MECKLENBURG COUNTY  
Park and Recreation Department

MEMORANDUM

**DATE:** January 23, 2024

**RE:** Rezoning Petition #2023-169  
PID# 11146120

REZONING PLAN
RZ.01

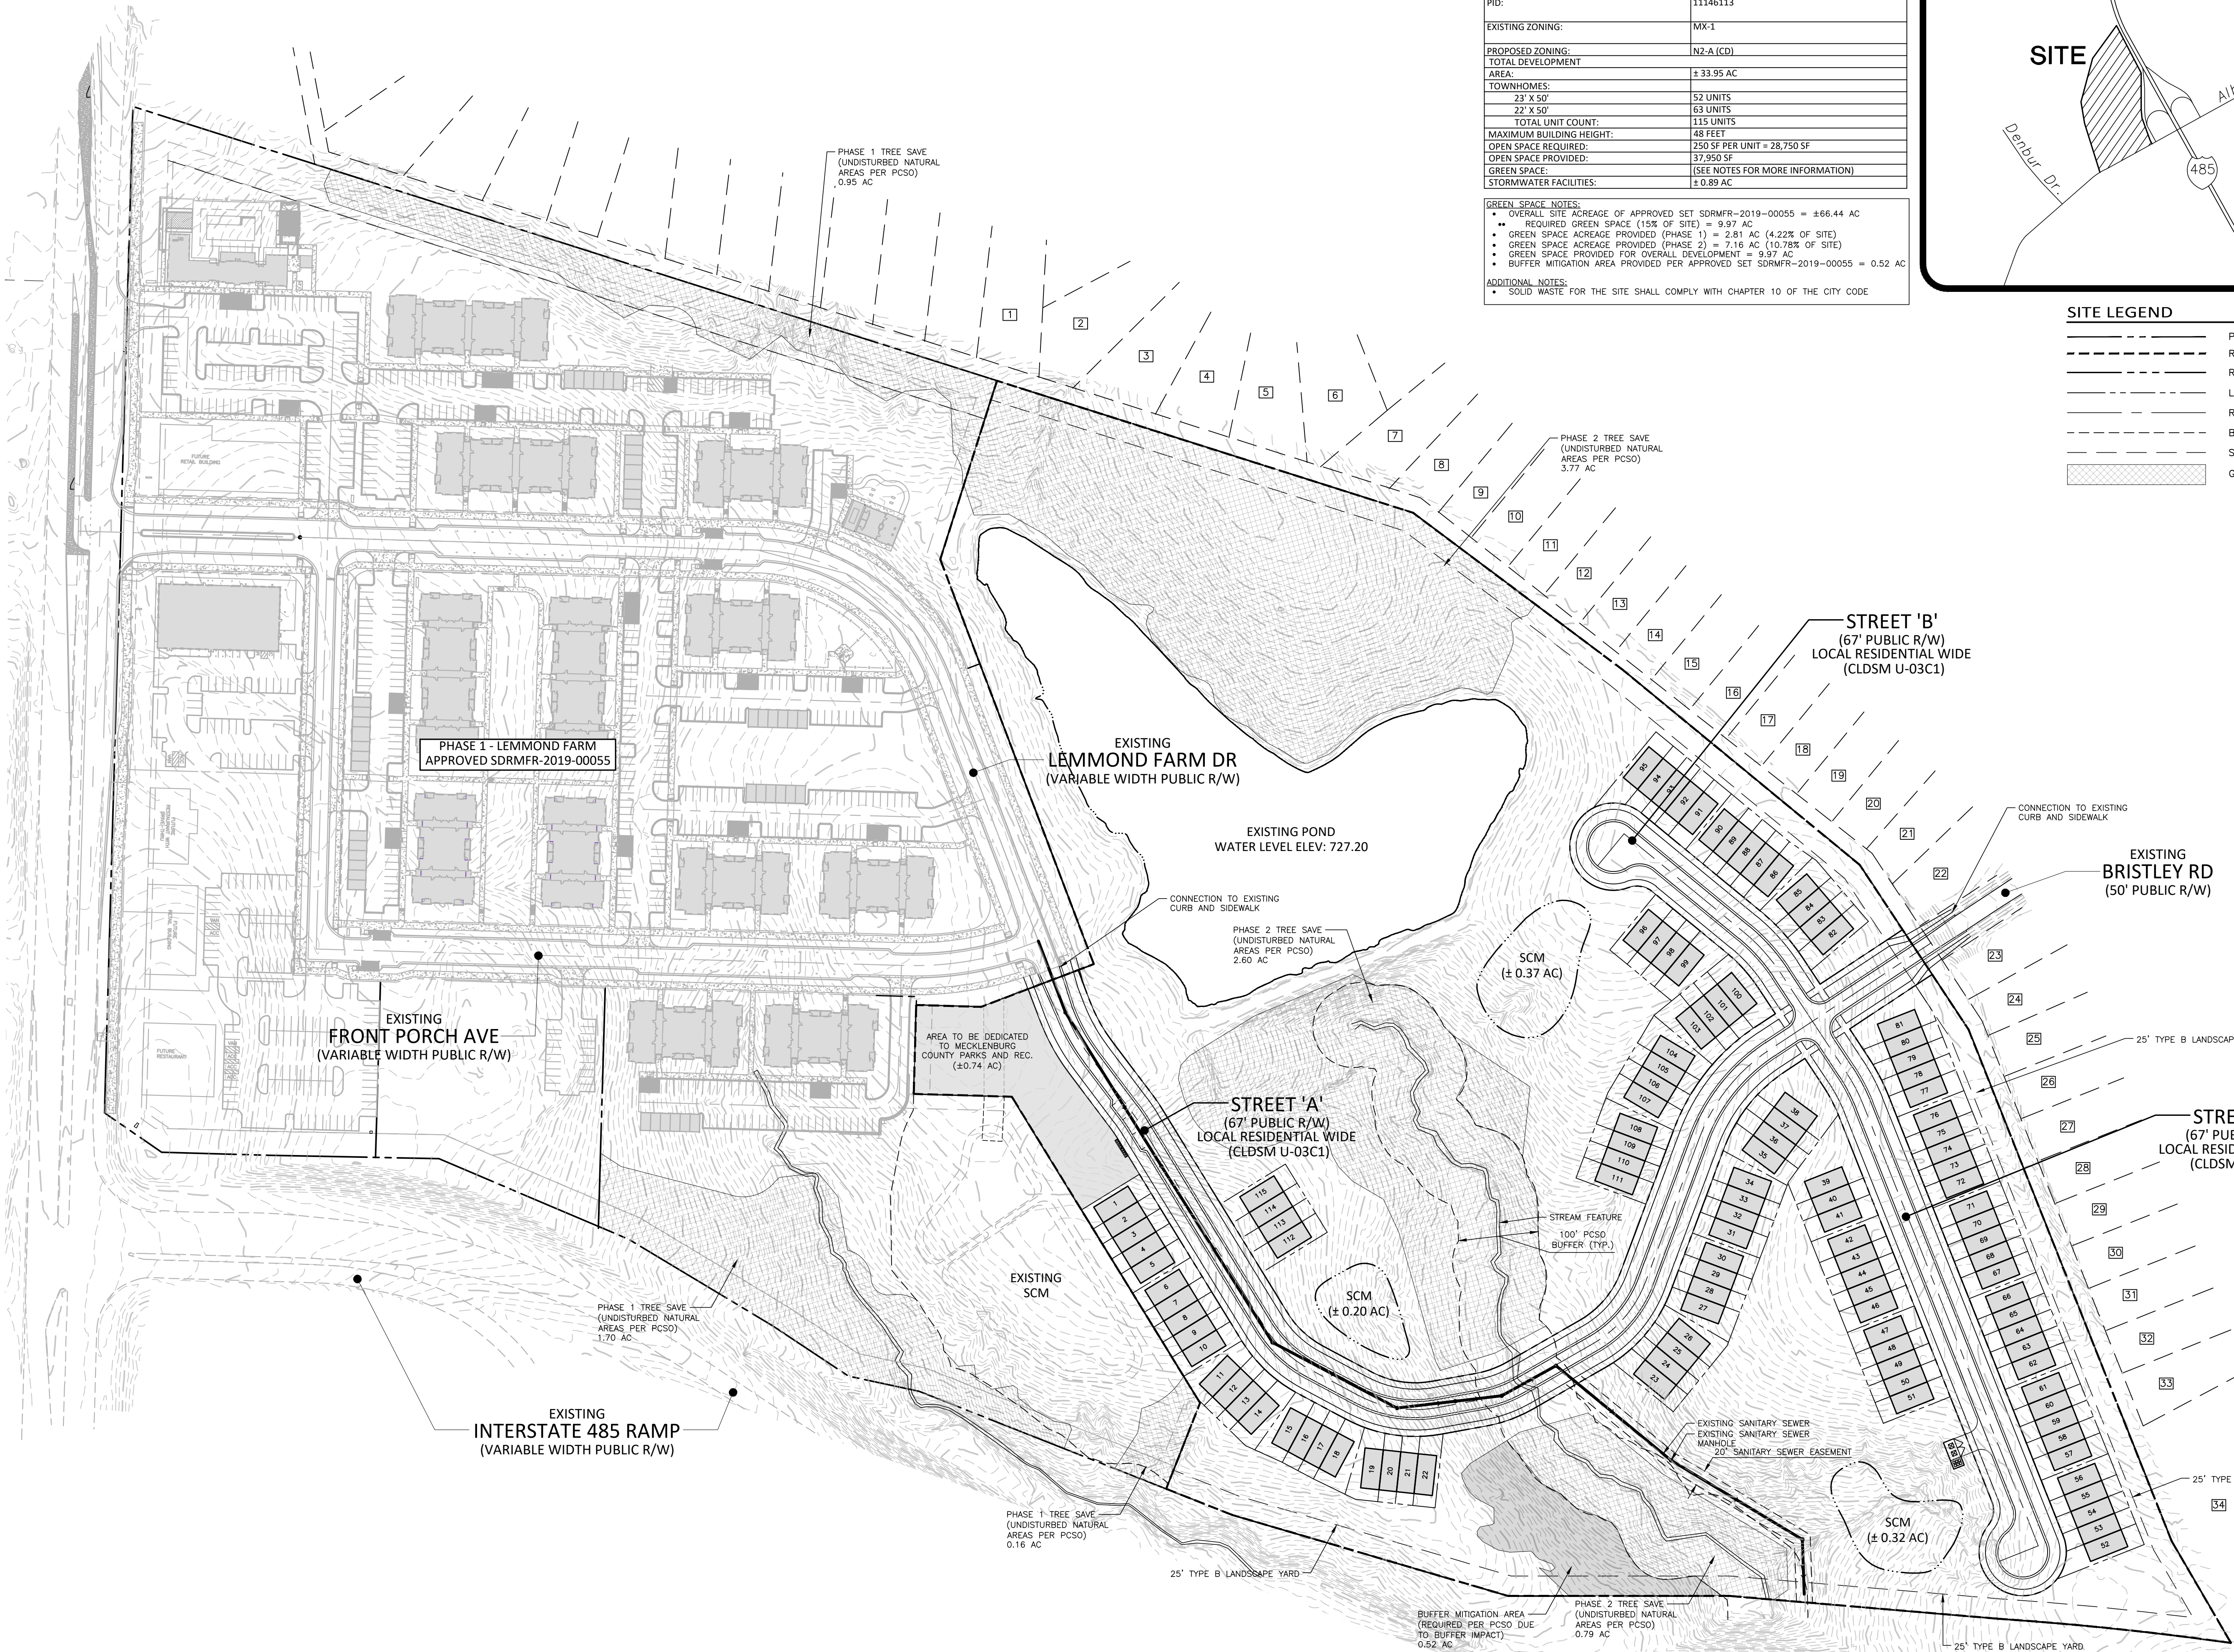
The local park dedication is acceptable as shown on the current site plan. If the area shown within the park dedication is a proposed mail area, include any necessary easements or subdivision in the approved plan. The site plan notes should read "dedicated and conveyed to Mecklenburg County prior to the issuance of the first C.O."
